Application No: AW/344/14/HH

Recommendation Report for Planning Permission for Works or Extension to a Dwelling

LOCATION: 68 The Drive
Bognor Regis

Drg No. 68/2014/20P	Rev A
------------------------	----------

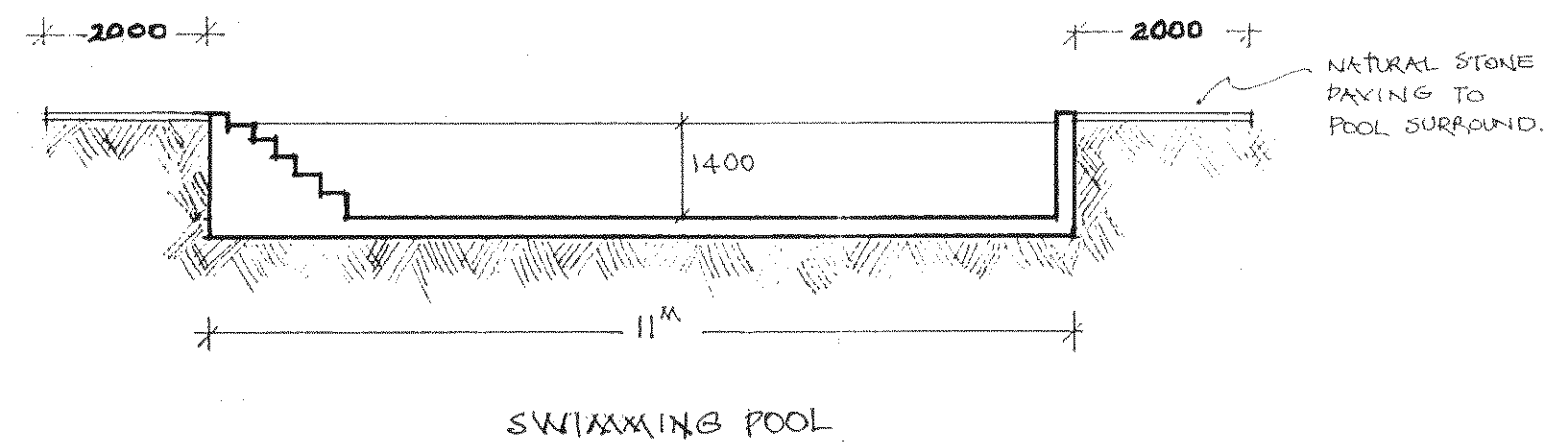
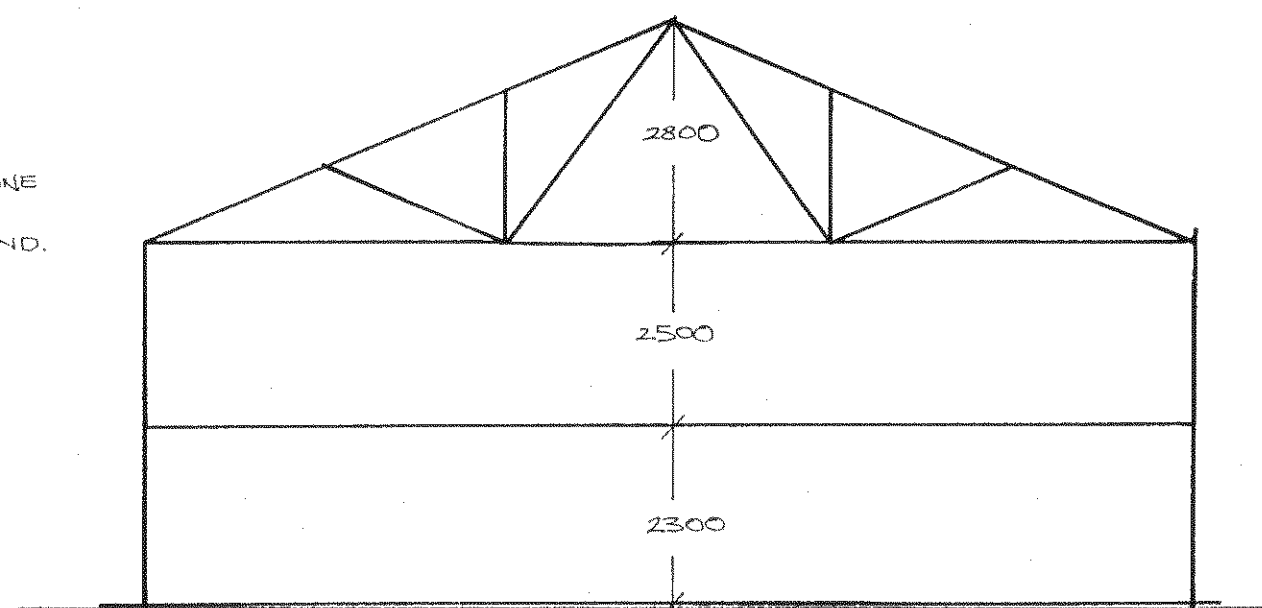
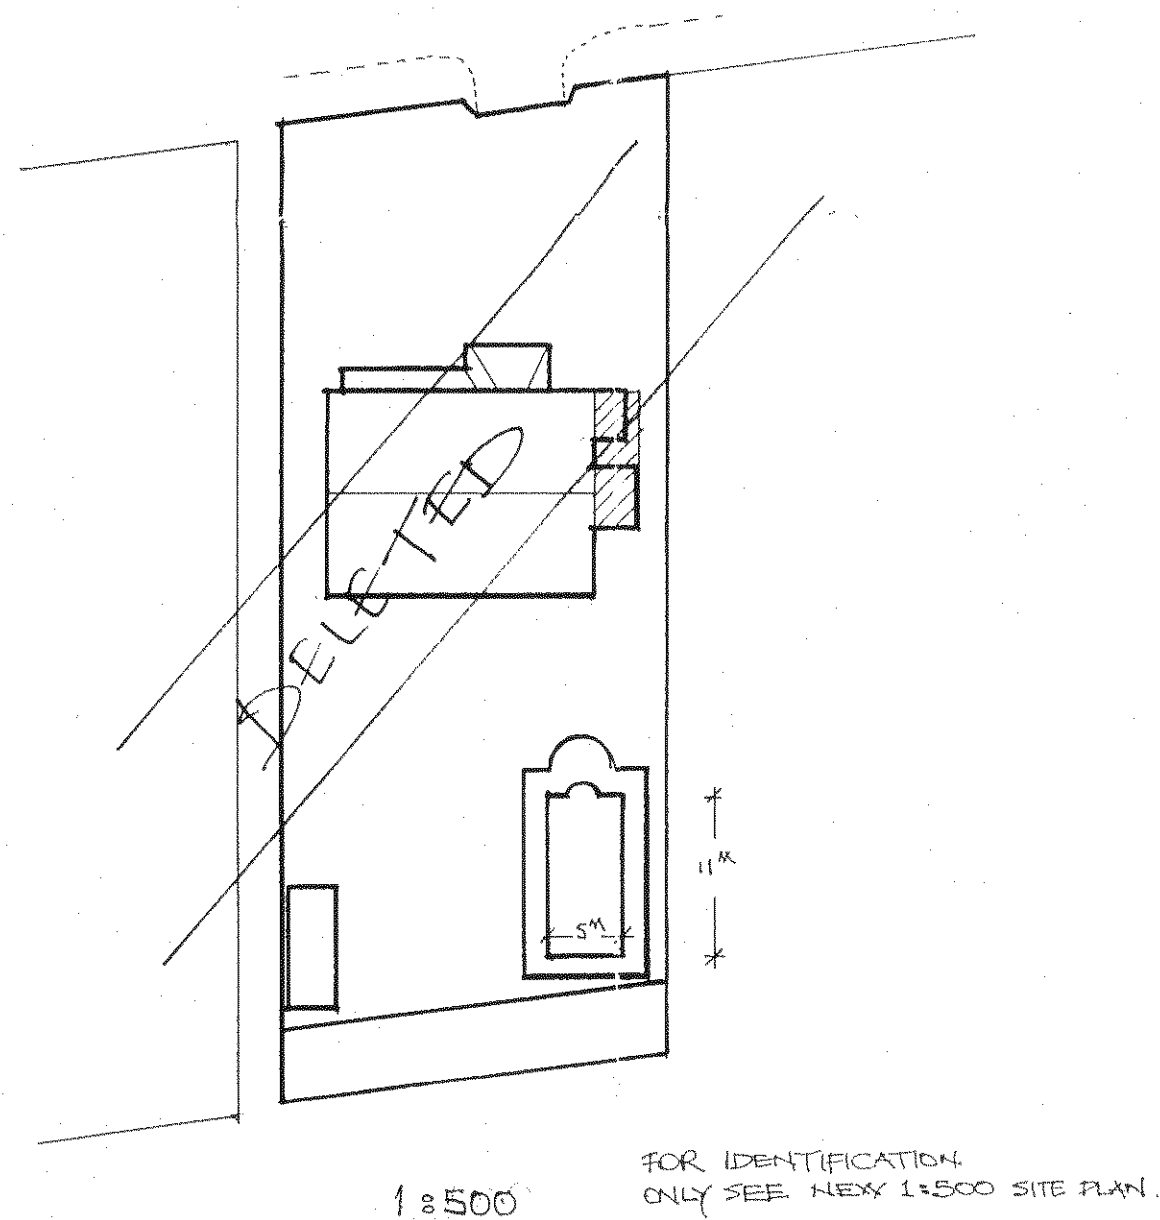
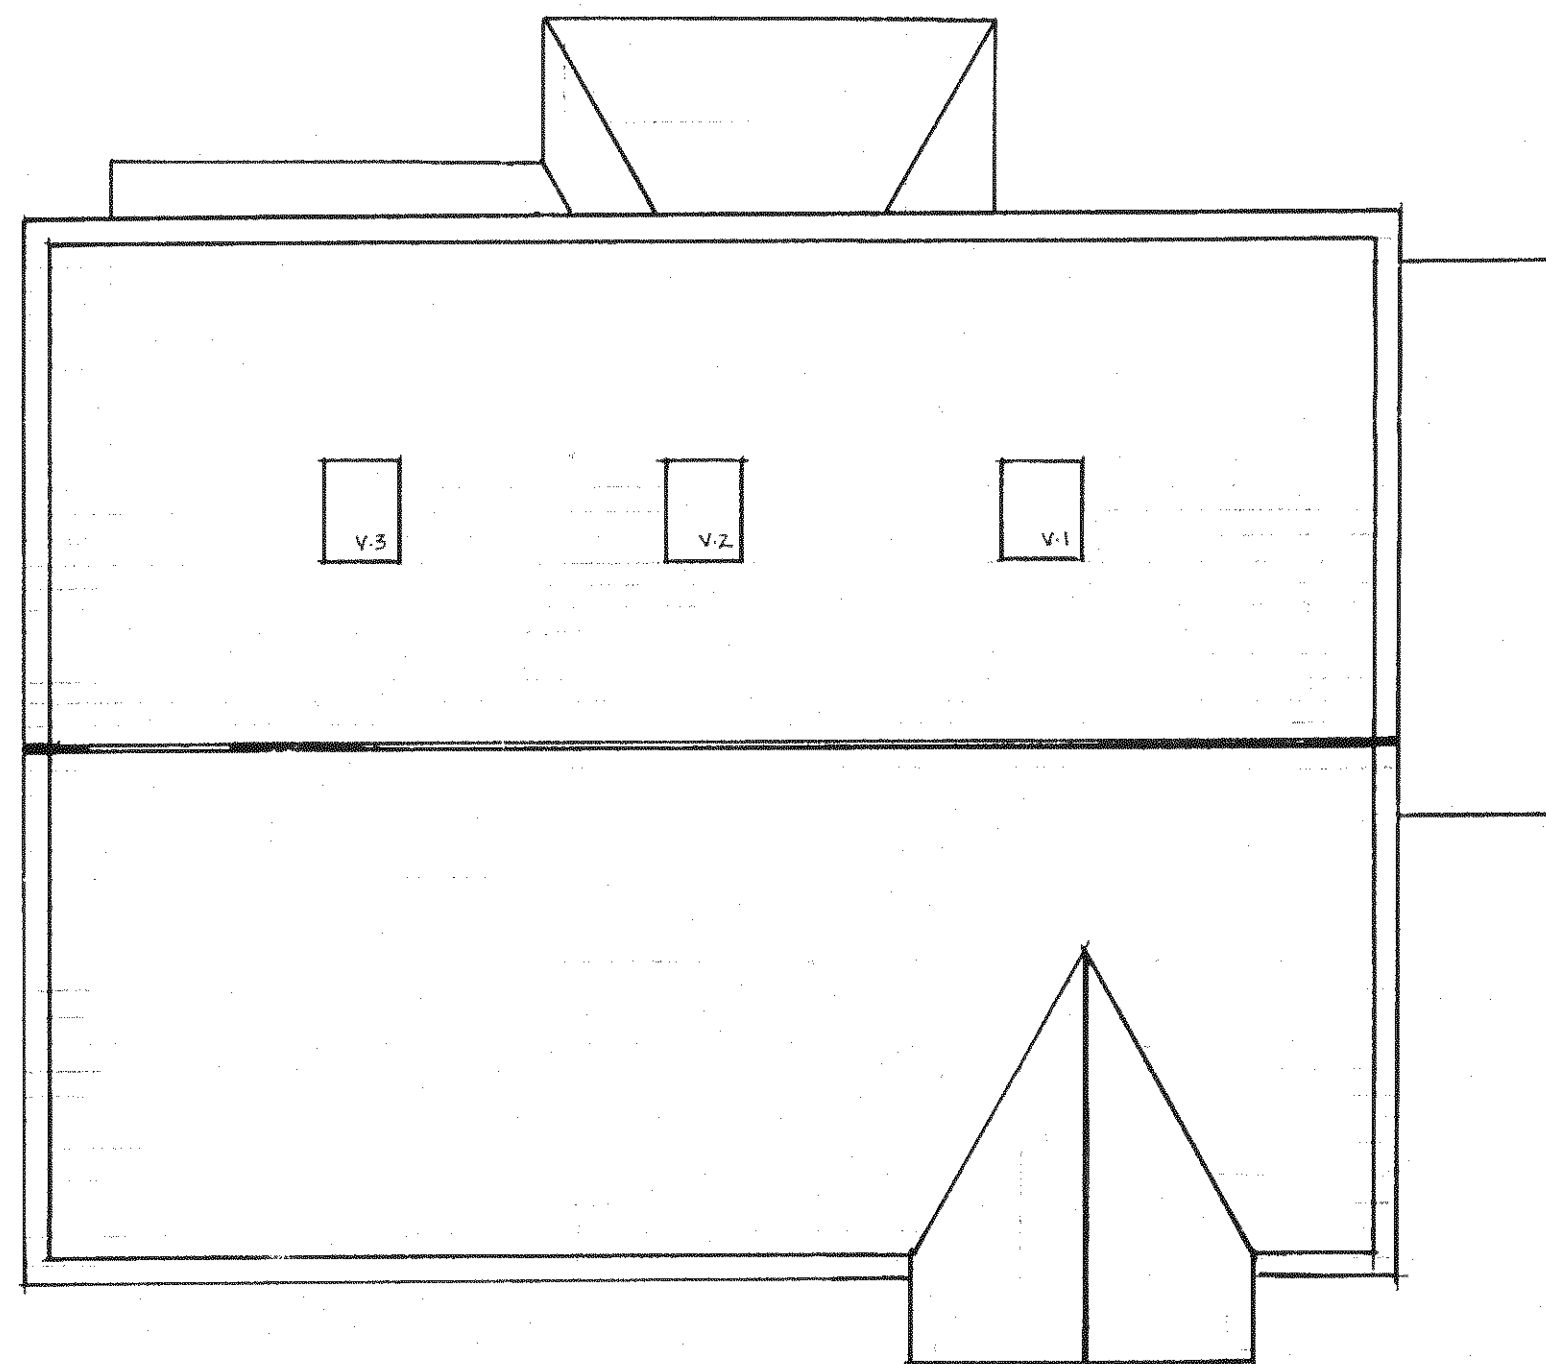
- *The proposed gable end to the rear of the property is not deemed to adversely impact upon the character of the conservation area, but will constitute an improvement to the appearance of the existing first floor extension.

- *The proposed gable roof by reason of its size and proximity to the boundary is not deemed to cause unacceptable overshadowing in conflict with policy DEV19 (iii).

It is proposed that the roof materials on this dwelling will be altered from the existing clay tiles to that of Welsh slate. This has been identified by the Council's Conservation Officer as a potential issue as these materials "do not respect the established characteristics of the locality". However, it should must be considered that number 72 The Drive features a slate roof and as such there is some precedent within close proximity to the application site of similar materials being employed.

- 3 The roof lights hereby approved on the northern elevation shall be of a conservation standard and shall at all times remain to this style.

- 4 No development shall be carried out unless and until a schedule of materials and finishes and samples of such materials and finishes to be used for the walls and roof of the approved development have been submitted to and approved by the Local Planning Authority and the materials so approved shall be used in the development.

Drg No
68/2014/40P

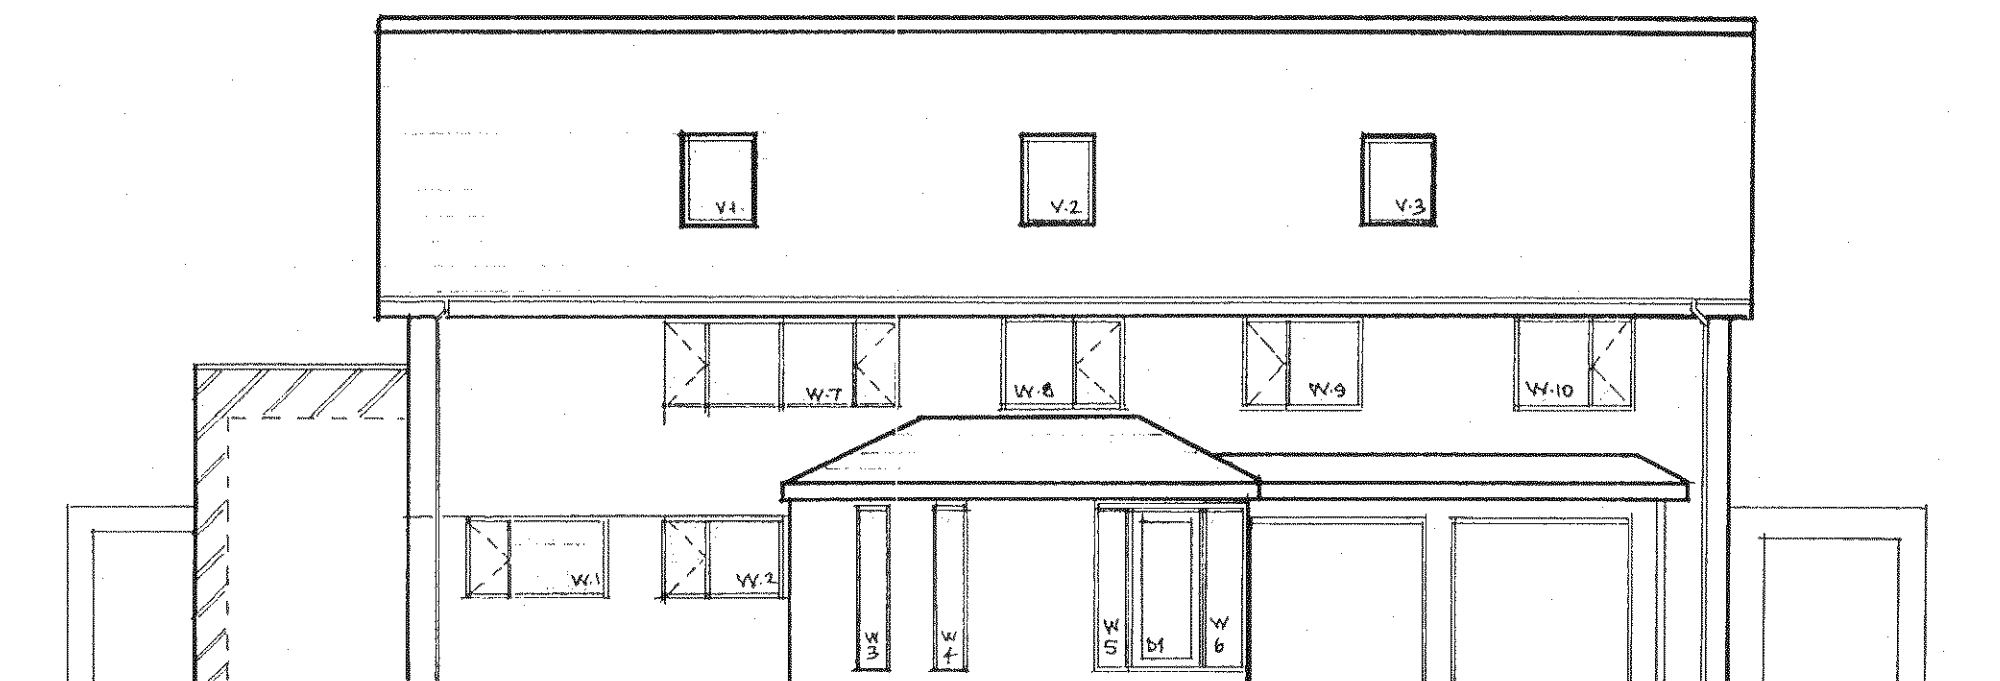
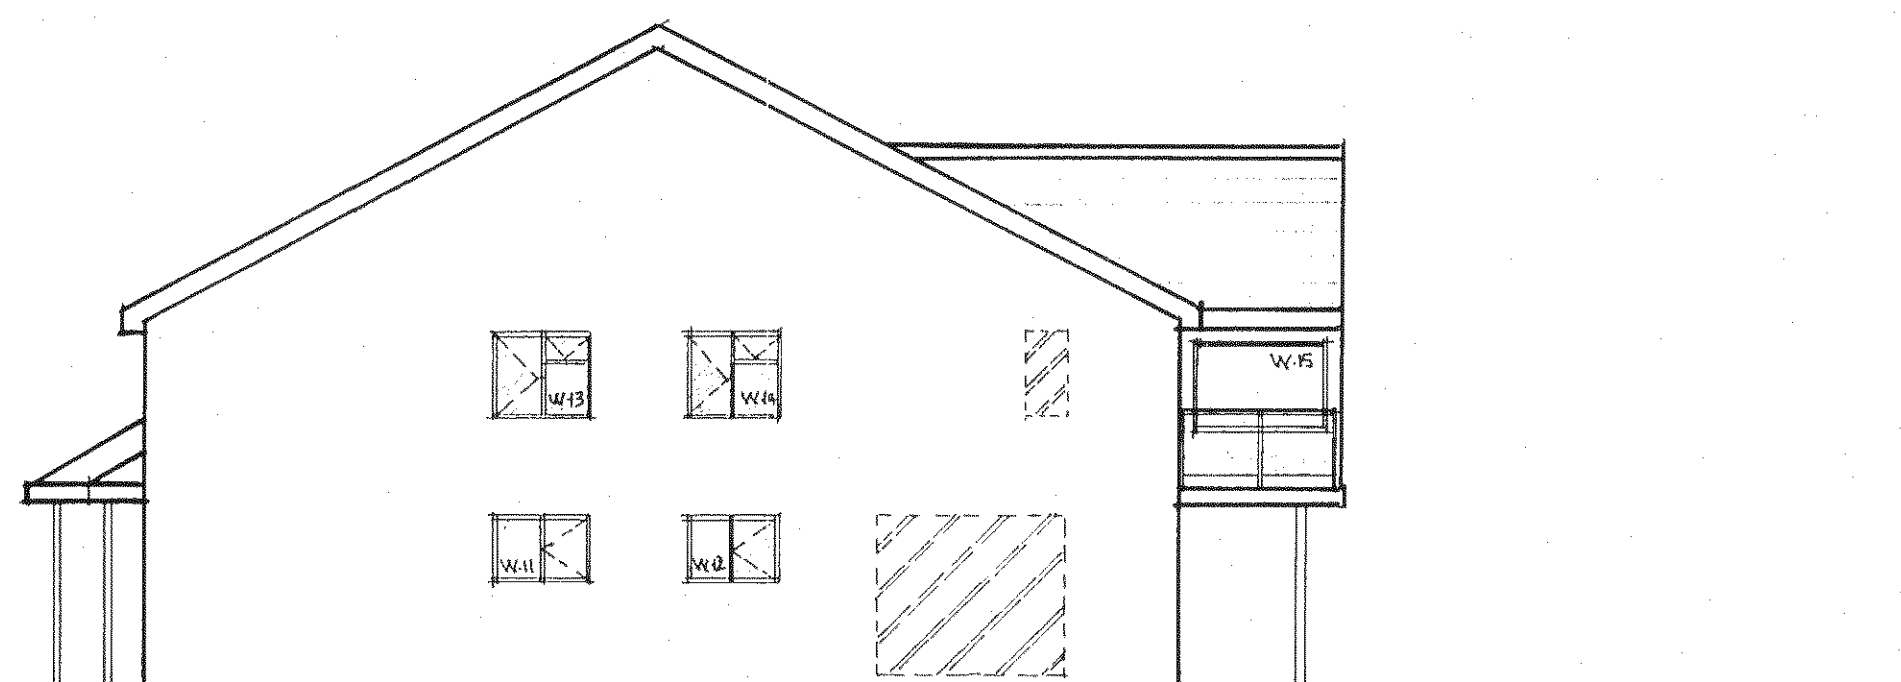
The application includes the addition of 3 No. velux windows in the primary elevation. These works could be completed under Schedule 2, Part 1, Class C of The Town and Country (General Permitted Development) Order 1995 (as amended) without the need to obtain planning permission from the Council. However, as they feature on the application they have been considered and have been deemed to not adversely impact upon the character of the conservation area. It was recommended by the Council's Conservation Officer that a condition be included on any approval requiring these windows to be of Conservation Grade and as such this condition will be imposed on any approval.

68/2014/30P

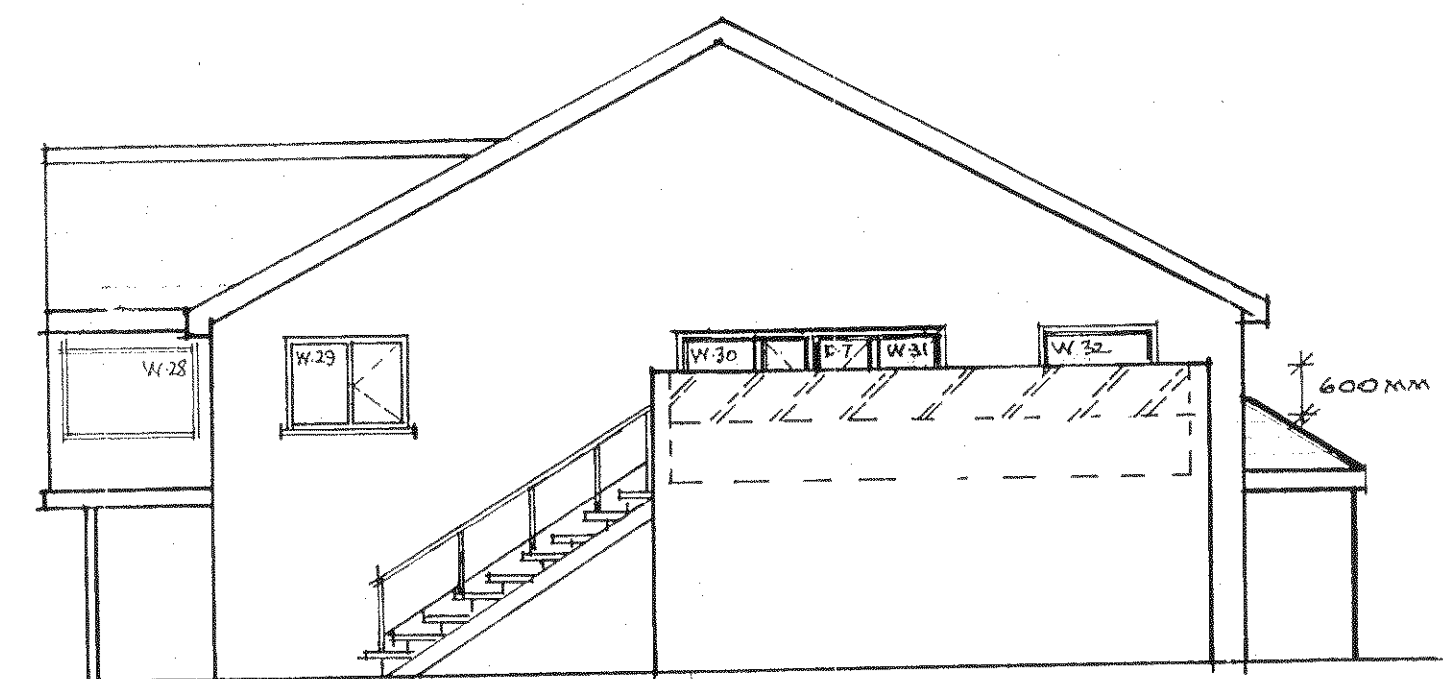
Further, the proposal introduces a revised living room 'bay' window with a revised roof. This increases the prominence of the structure on the rear elevation, which is unfortunate.

The removal of the rear steps and the replacement of the balcony with a larger one constructed

with a steel handrail and glass supports, further increases its presence on the rear elevation.

The proposed alterations to the eastern elevation of the property will see an increase in size of the existing balcony and potentially give rise to additional overlooking of the adjoining property at 70 The Drive. It is also felt that the proposed alterations to the rear balcony have the potential to create additional overlooking of the property at 66 The Drive. However, this overlooking could be prevented through the use of planning conditions requiring the installation of obscured screening.

- 5 No development shall be carried out unless and until details of obscured screening up to 1.8 metres in height have been submitted for the eastern wall of the balcony on the eastern elevation and the western edge of the rear balcony have been submitted to and approved by the Local Authority. The screening hereby approved shall be constructed within 1 month of the completion of this development and thereafter permanently retained.
